**RE: Sunraysia Solar Farm, Balranald LGA - Environmental Impact Statement (SSD 7680)**

## ATTACHMENT A – Detailed comments for Sunraysia Solar Farm, Balranald, Environmental Impact Statement (SSD\_7680)

Figure 5-1 Proposed development and operational footprint - South

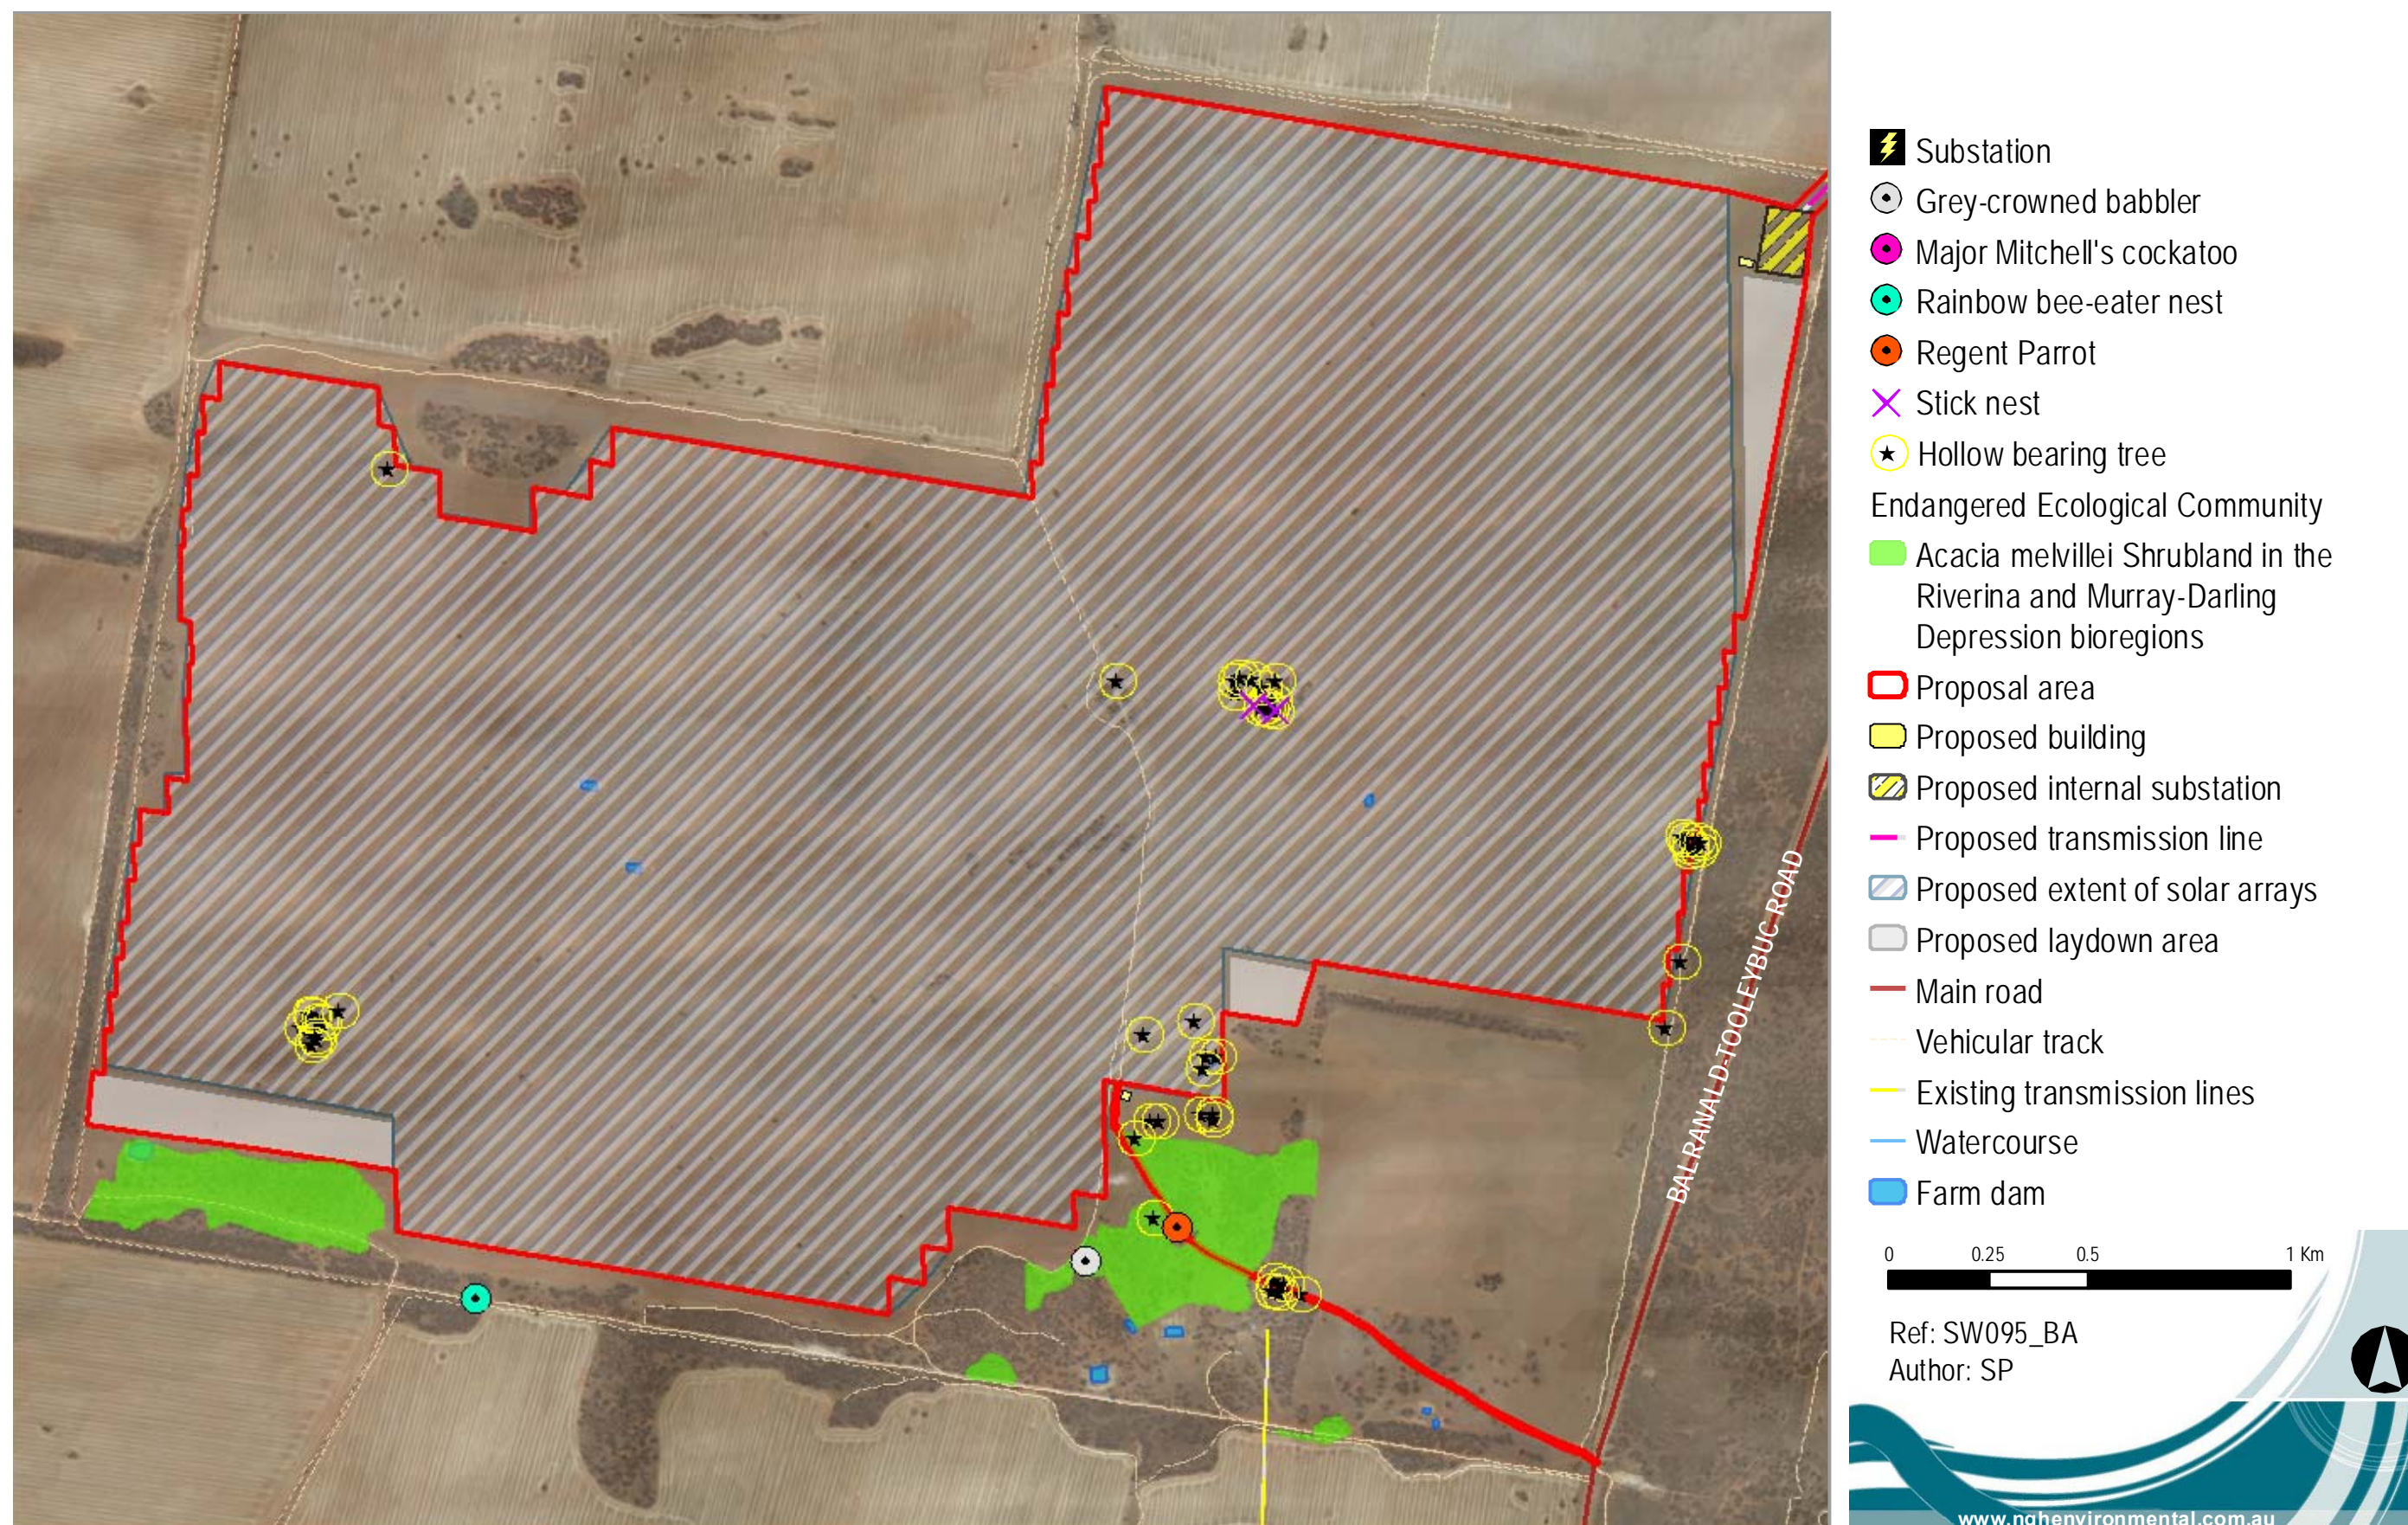
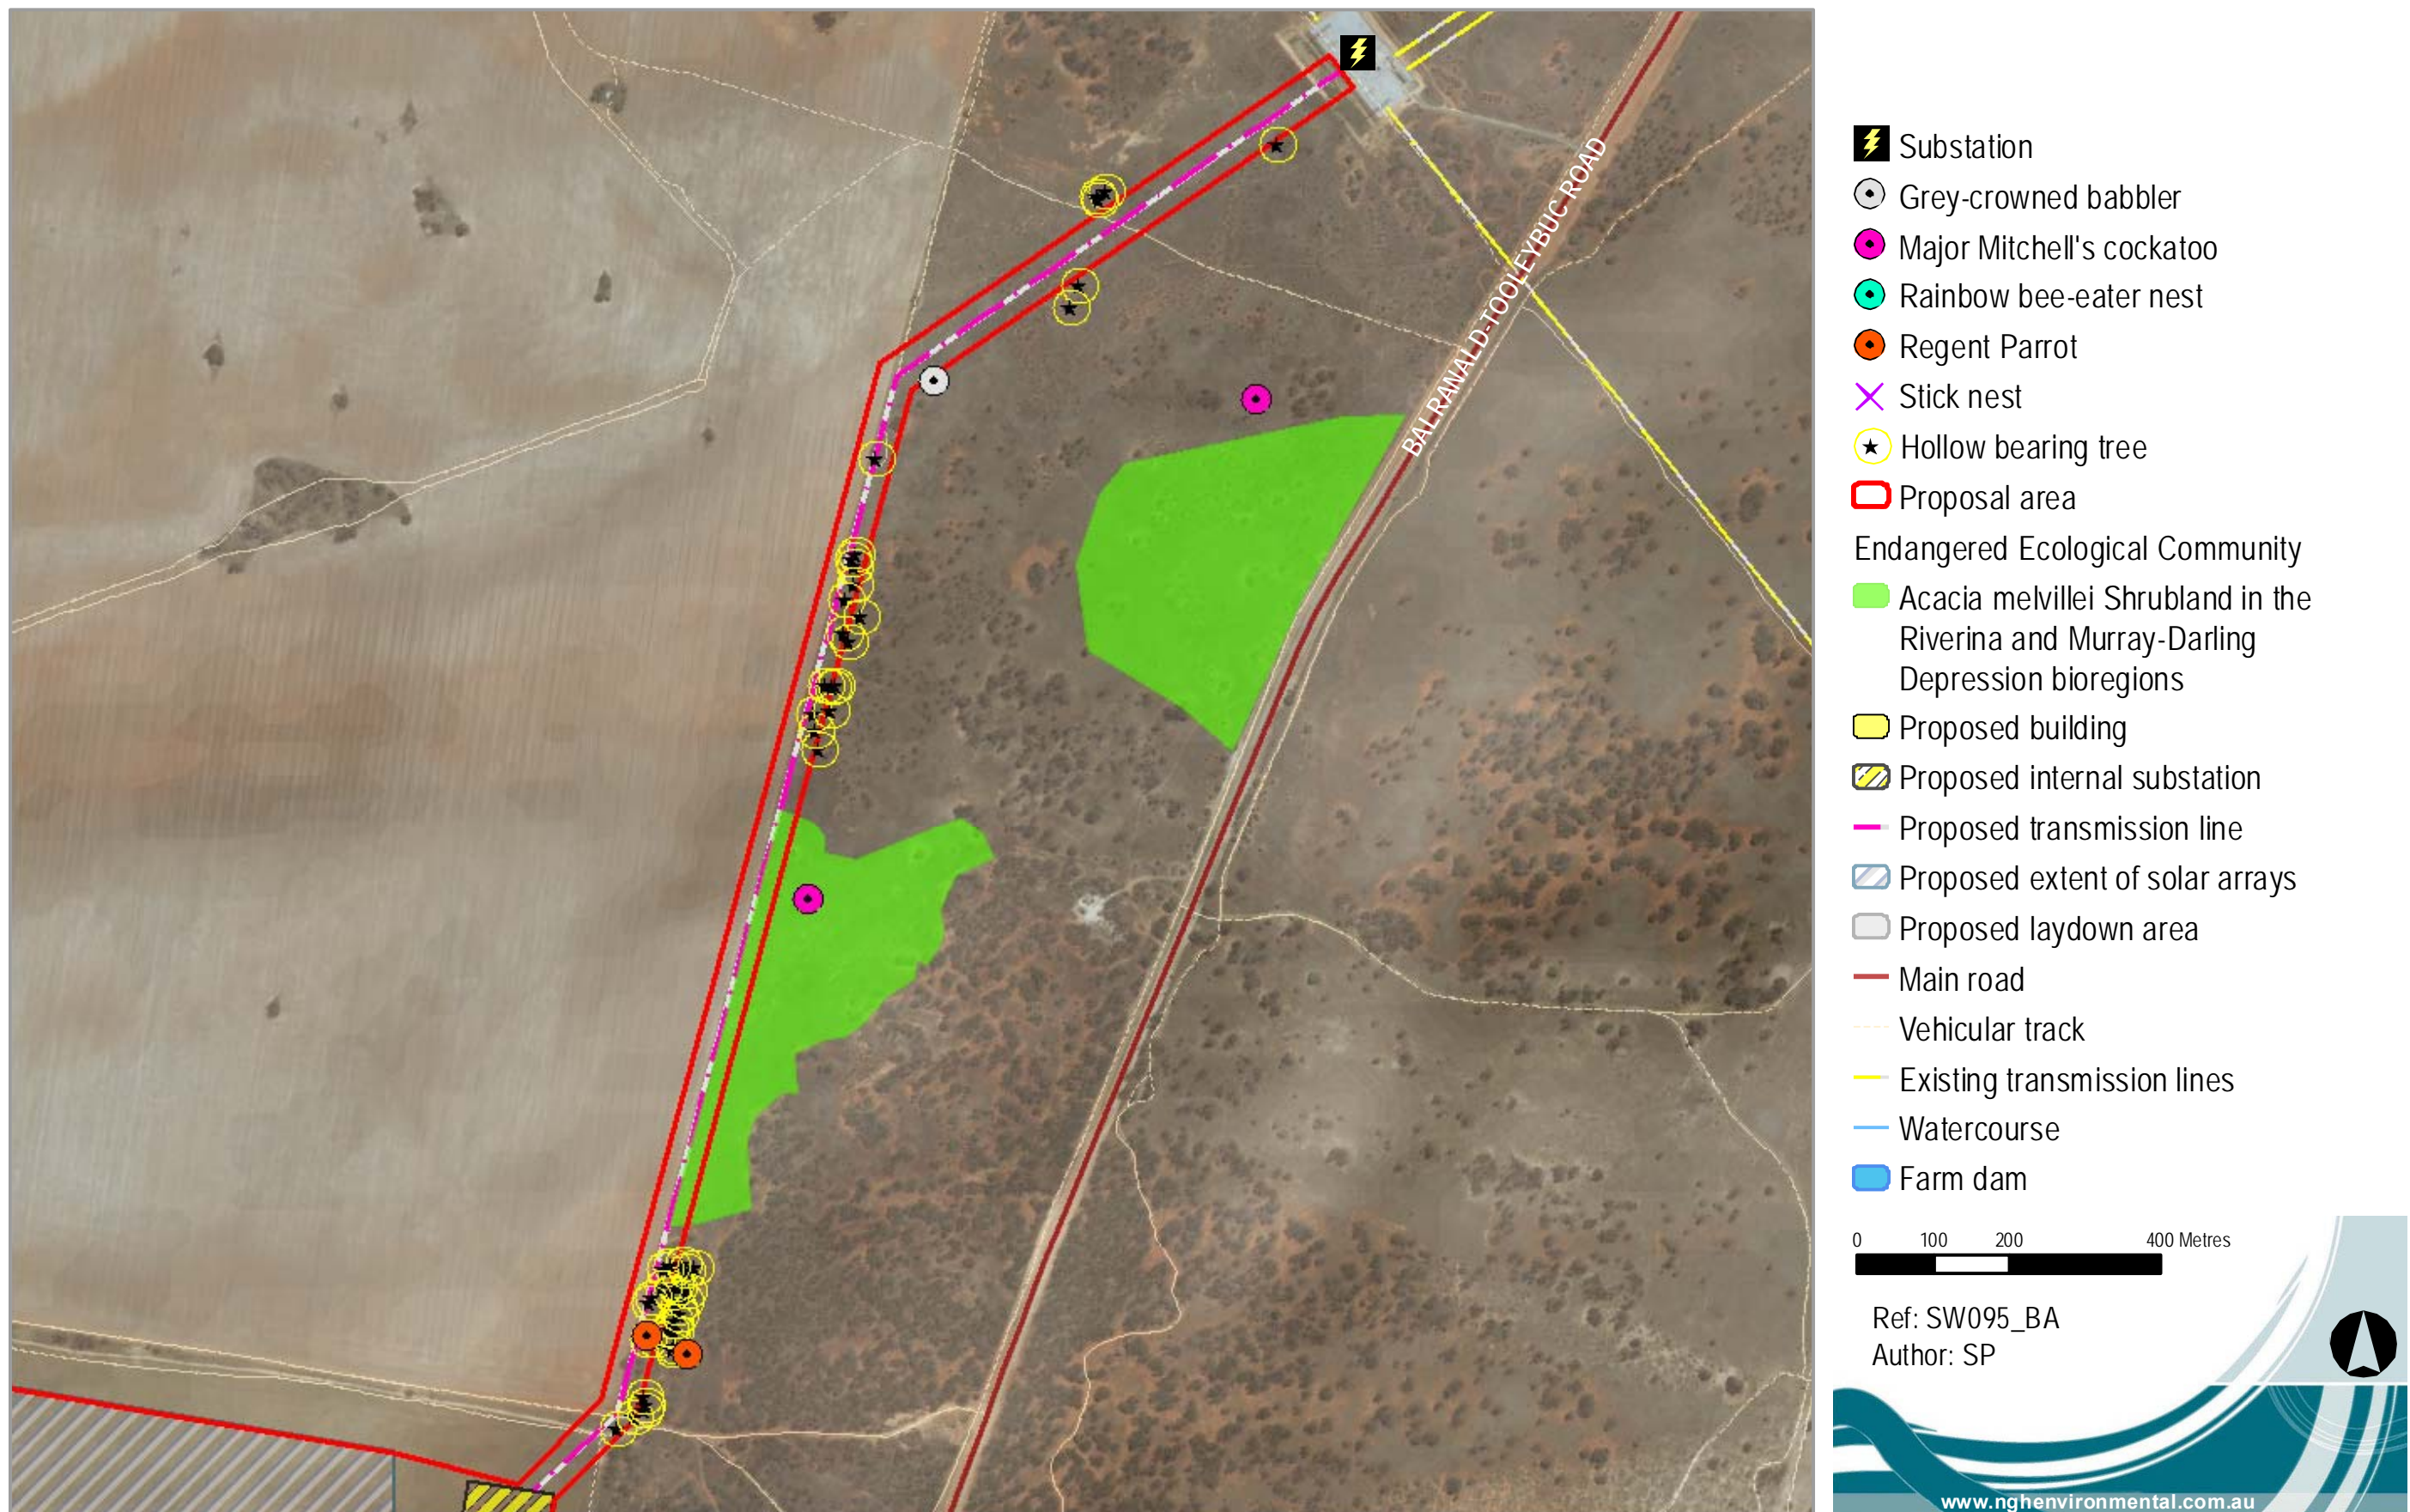
We understand that the site access and internal tracks will be determined during the detailed design phase. However, any additional vegetation clearing to upgrade existing roads from one to two lanes needs to be specified and assessed for impacts to threatened species and communities. It is unclear if the vegetation clearing and soil disturbance for construction of the perimeter security fence has been included in the impact assessment. The width of the cleared corridor required for the proposed 2.3 km transmission line should also be specified in the EIS or the BAR.
